Lansdowne 2.0 - Event Centre

Response to Comments

Site Plan Control (D07-12-24-0082)

DWG. NO. C04

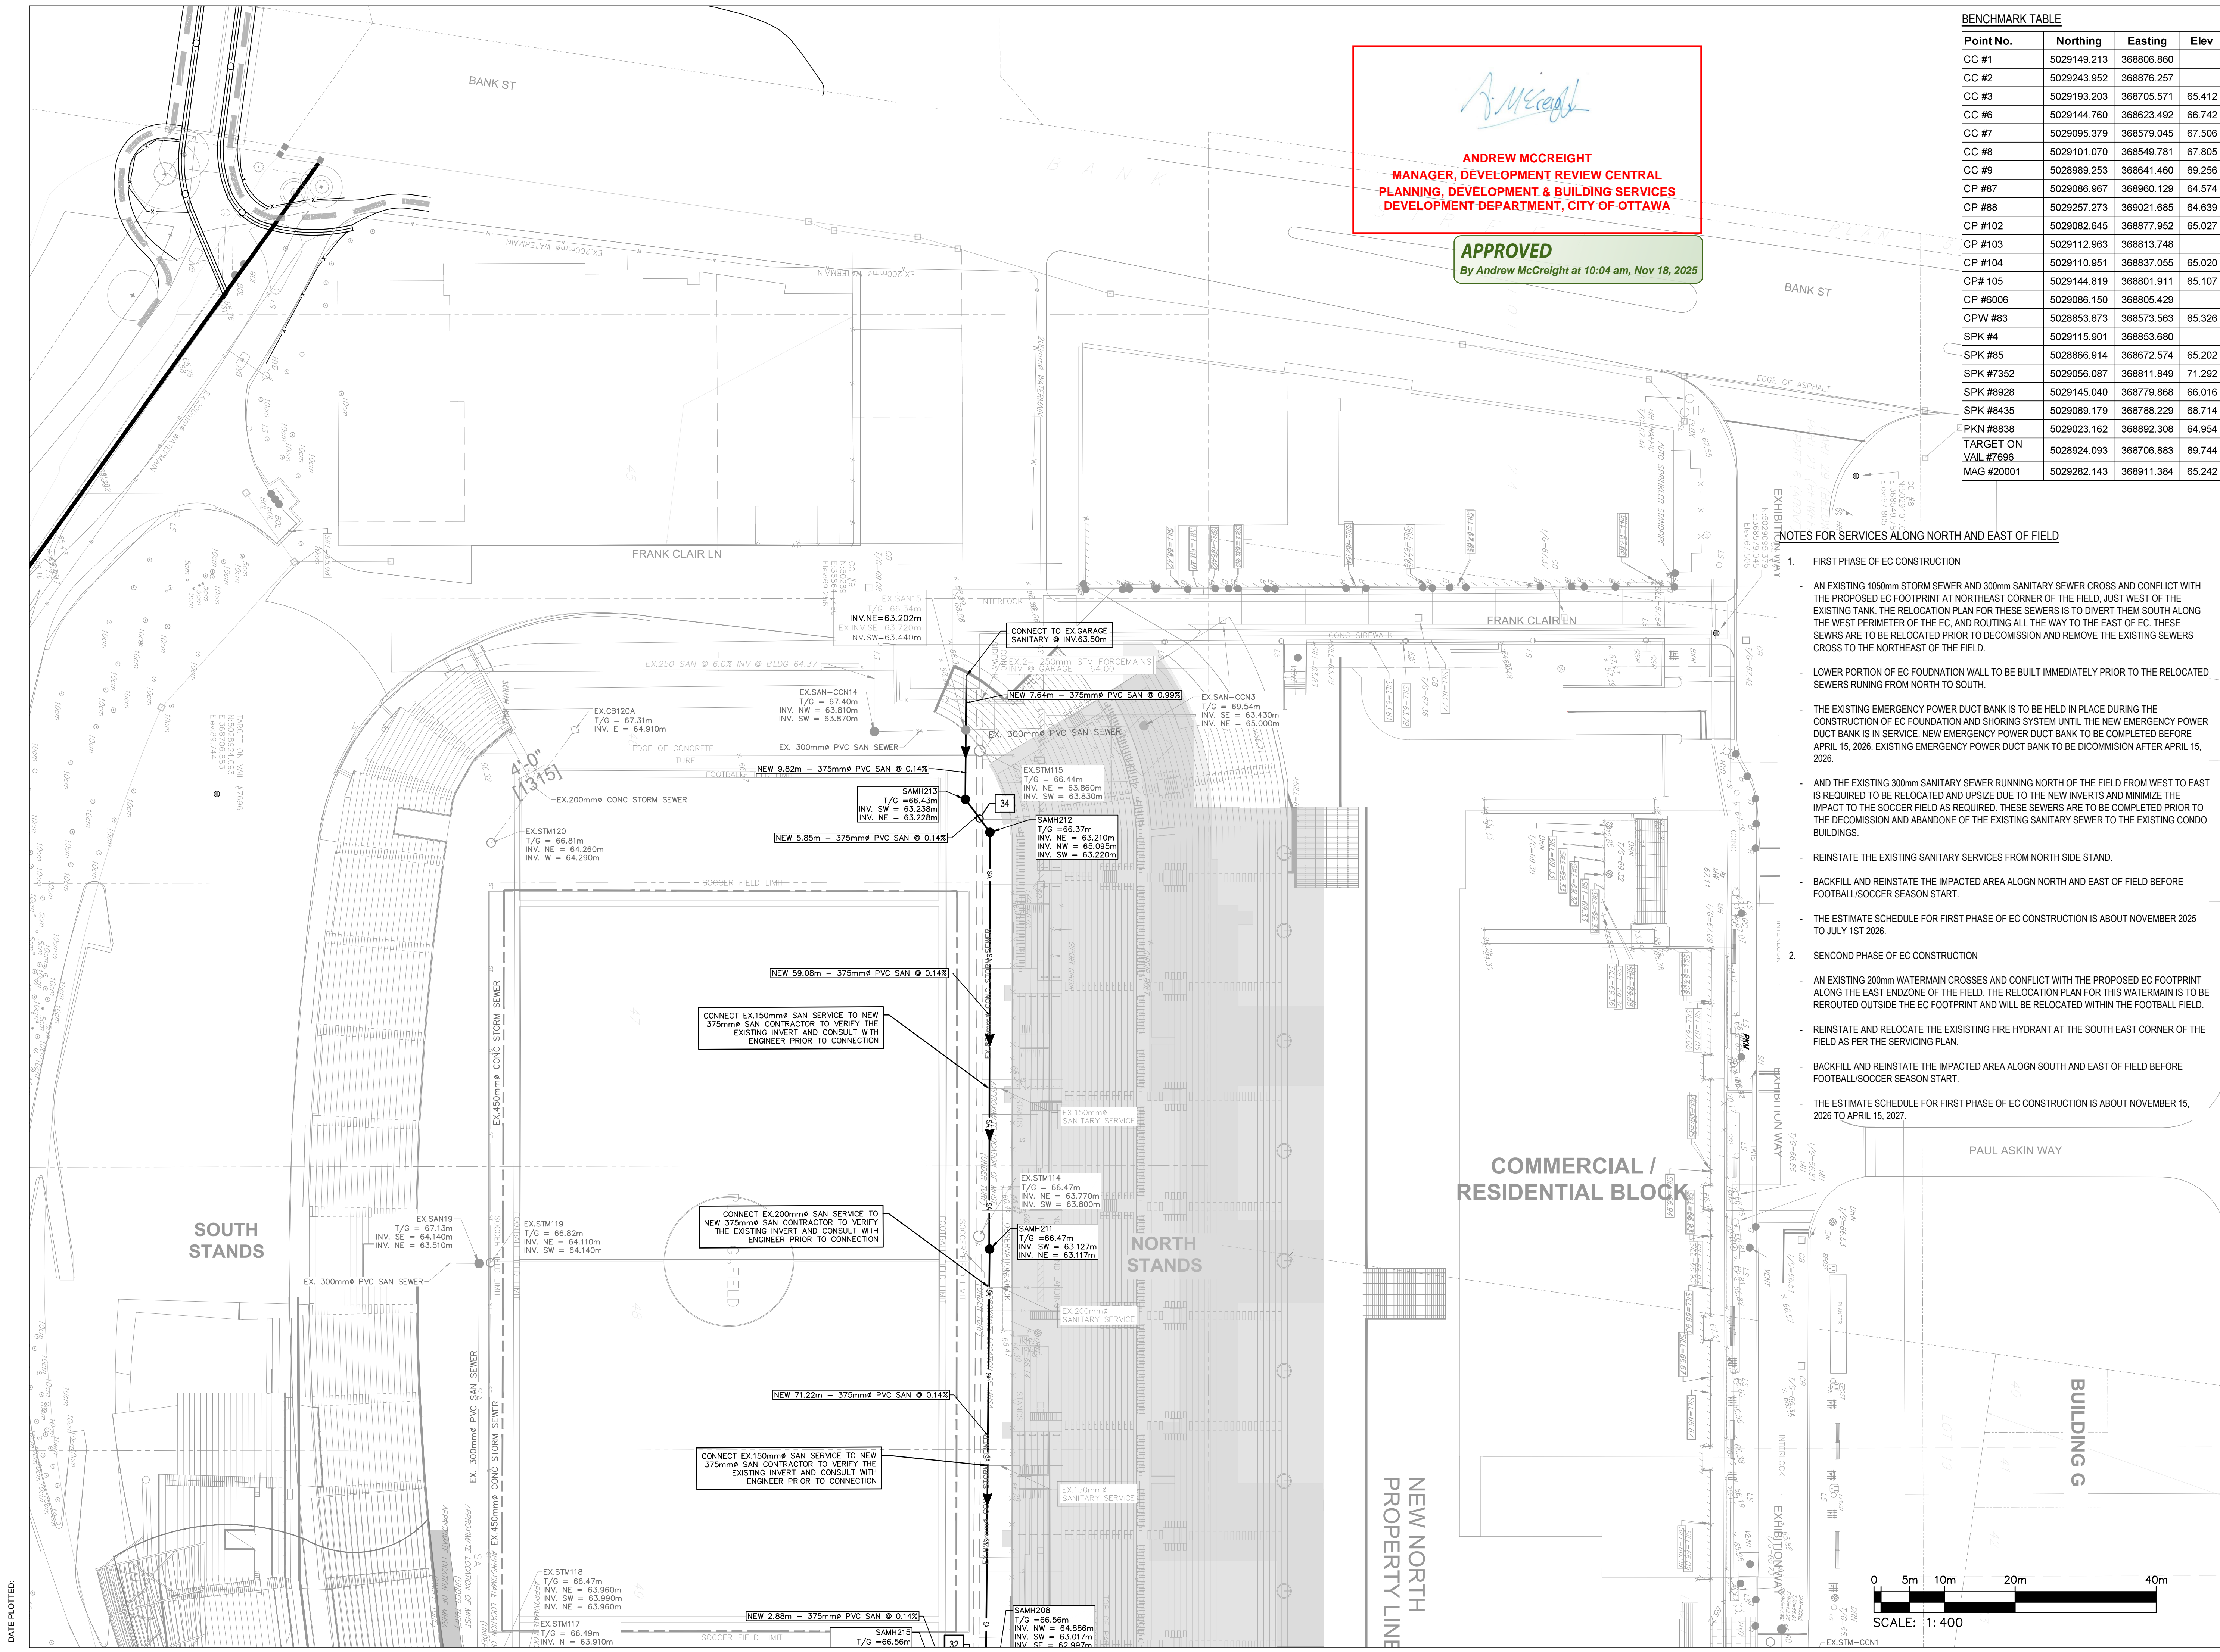
3.28	The finished floor elevation of the Aberdeen pavilion is 65.44, grades abutting the Aberdeen pavilion are 65.45 please ensure that there is sufficient positive drainage away from the Aberdeen pavilion.	WSP	The grades abutting the pavillion have been revised to be lower than or equal to the FFE. There is sufficient positive drainage away from the building.

3.29	Please show existing elevations of the existing loading dock which is proposed to be the new entrance for the underground parking access. Additional grades in this area are required to ensure that the storm flow route will not spill in this location. Confirm that the major over land flow route will not spill into the reverse slope loading dock.	WSP	The loading dock area grades are per existing conditions. No grading changes are proposed north of the ramp entrance. The entrance is as at high point so storm flow will not spill in this location. All available elevations as per the survey area already shown on the grading plan.
	Servicing Plan, Drawing C05A, prepared by WSP Canada Inc, Project No. CA0033920.1056 Rev 5, dated January 15, 2025

SCALE 1:400
PROJ. NO. CA0033920.1056
DWG. NO. C05A

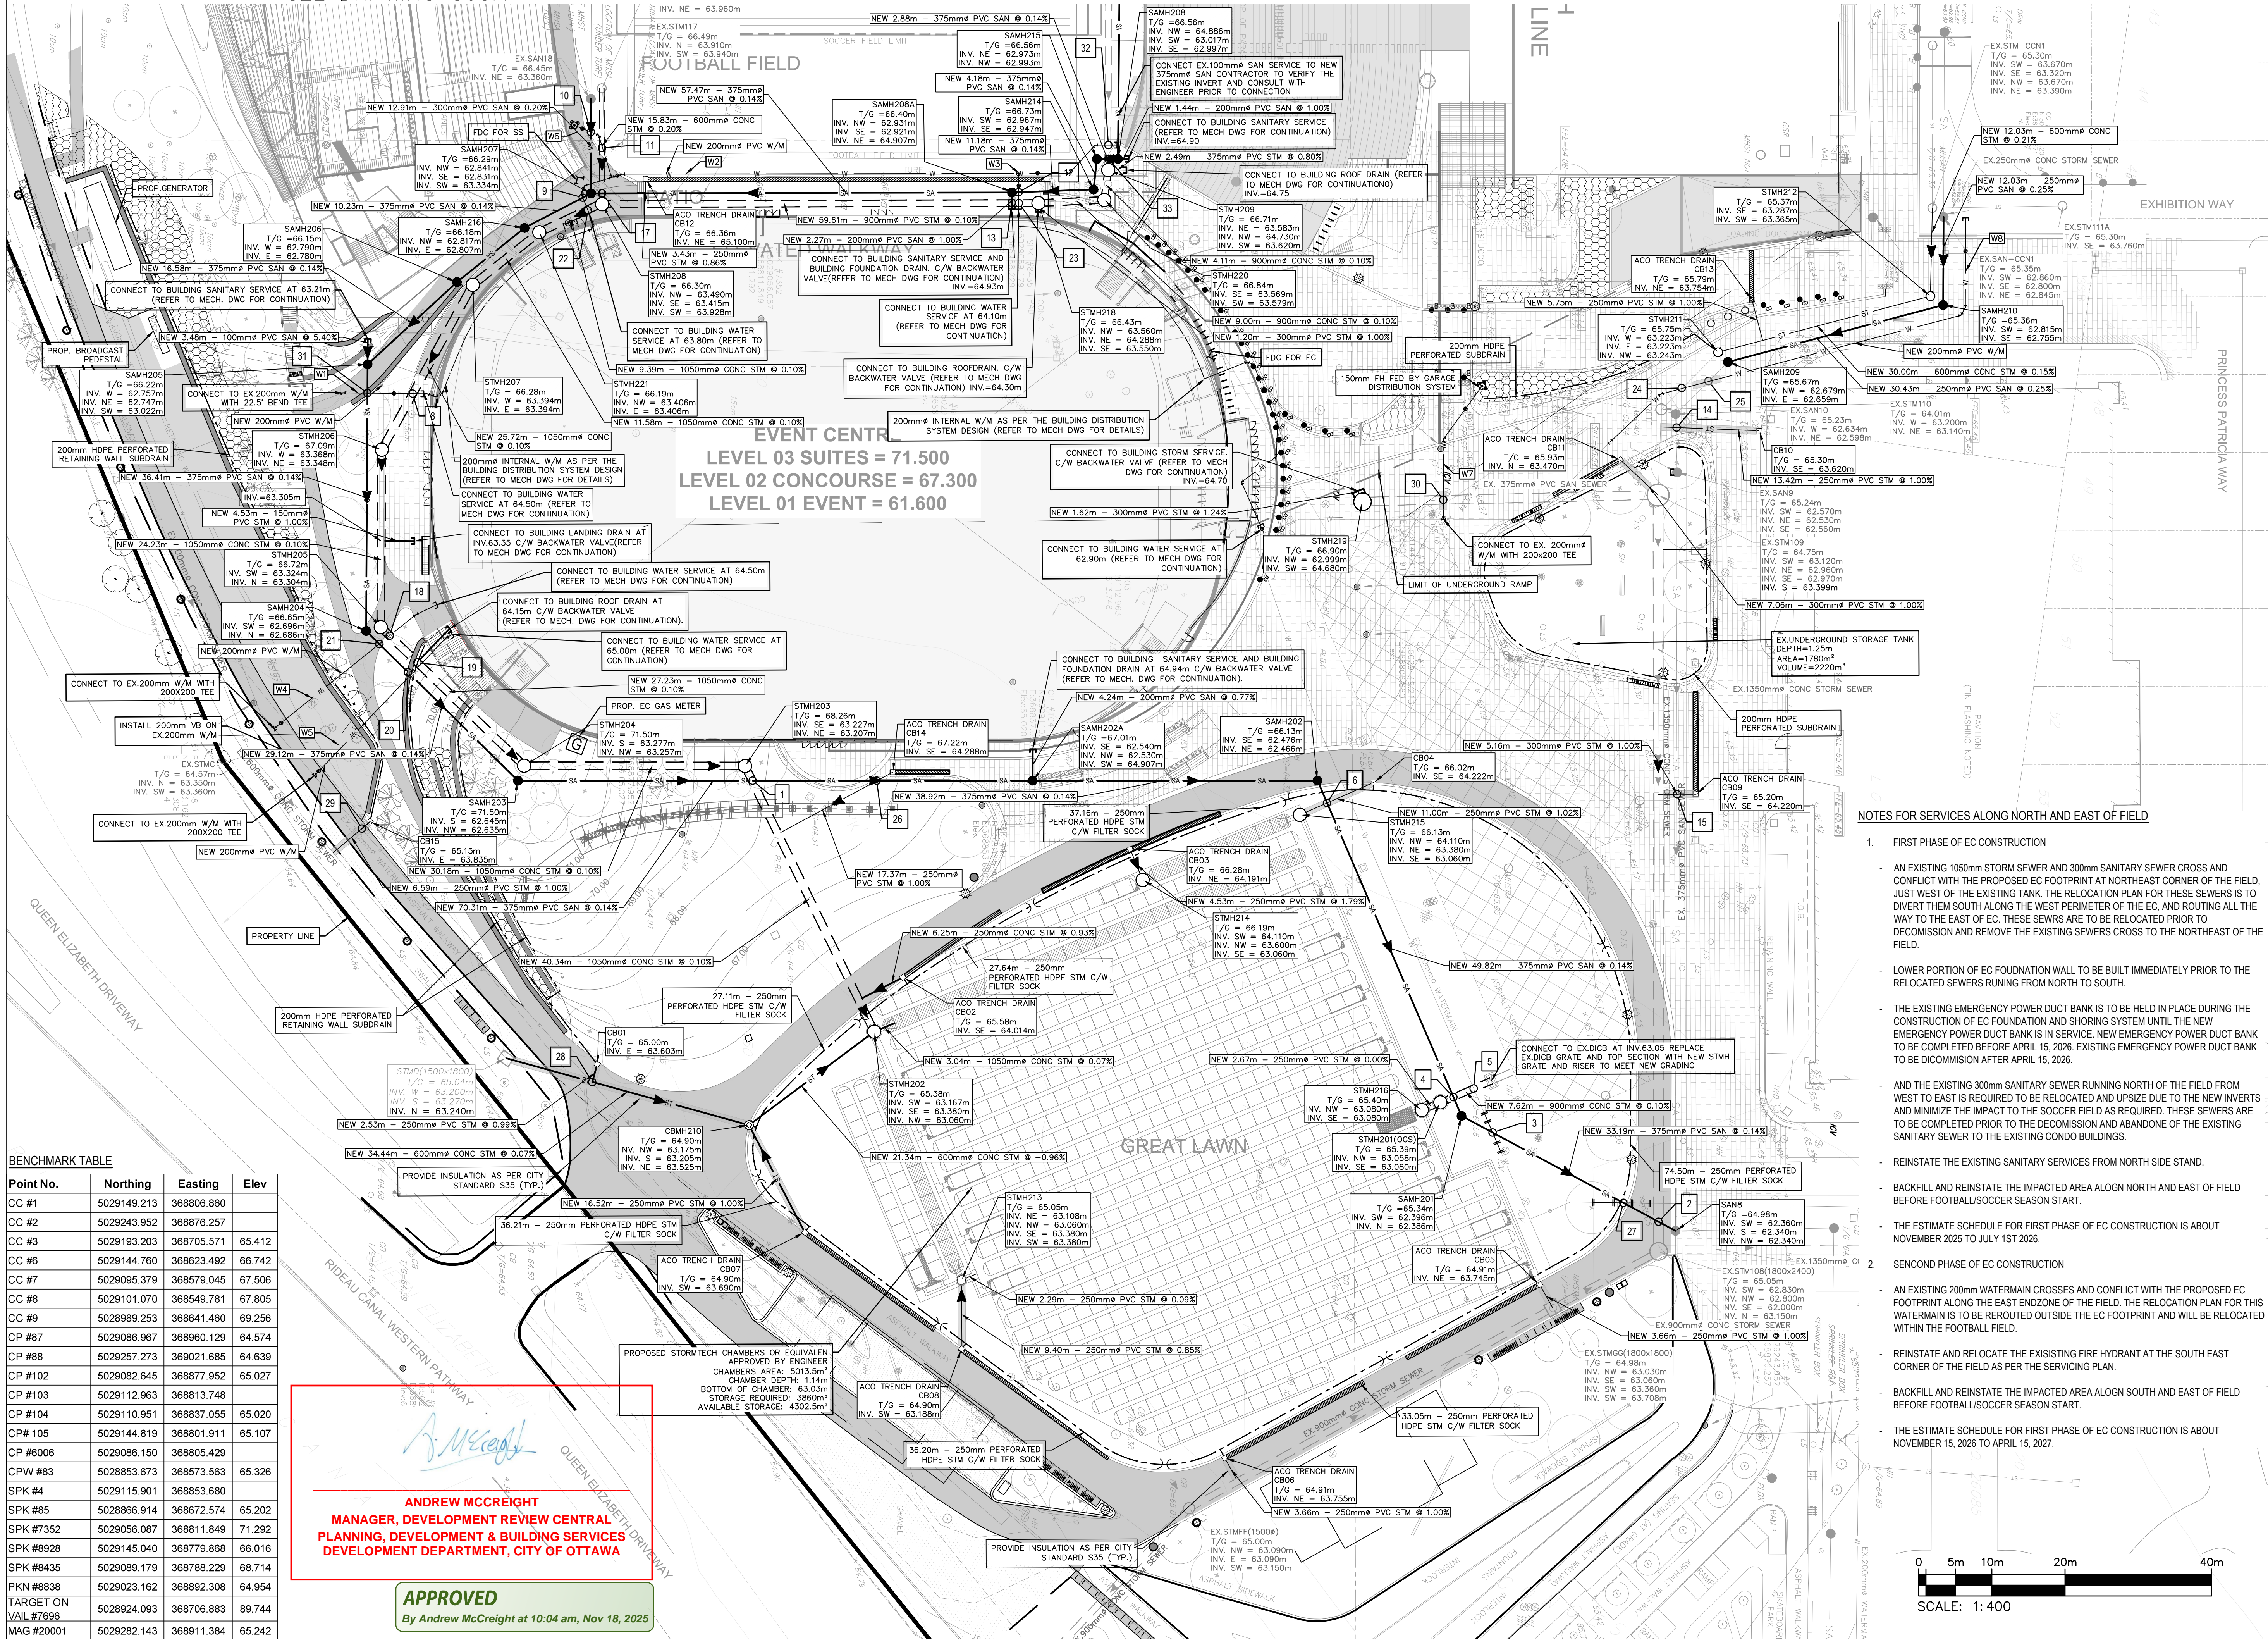
No.	Comment	Responsibility	
3.30	Please show fire route on the plan. Please confirm that any portion of the roof top of the underground parking garage will not have heavy vehicular access such as fire truck. If it does, roof top will have to be designed to withstand with the firefighting vehicular load. Please let us know and we will verify it from the fire service's unit. WSP response: Fire route location has been provided. It is located on the surface and not going to the underground level. City response: As per the site plan it appears that the fire route is proposed over the limits of the underground parking. Approval from the City of Ottawa fire protection Engineer Allan Evans (allan.evans@ottawa.ca) is required for any fire route access over underground structures. Confirm	WSP	Please see revised architectural site plan indicating the fire routes.

3.31	Are the roof drains controlled? Is the foundation drain discharged by gravity or by sump pump? Foundation drain and roof drain are being discharged via same storm service lateral which is not as per city guidelines. WSP response: No control for roof drains. Foundation drain will be pumped, they are not being discharged via same storm service lateral. City response: As per the servicing drawing it appears that the building foundation drains, and roof drains are discharging to the same lateral via two connections see below. 	WSP	Foundation drains to be pumped to sanitary. Roof drain to go to storm.
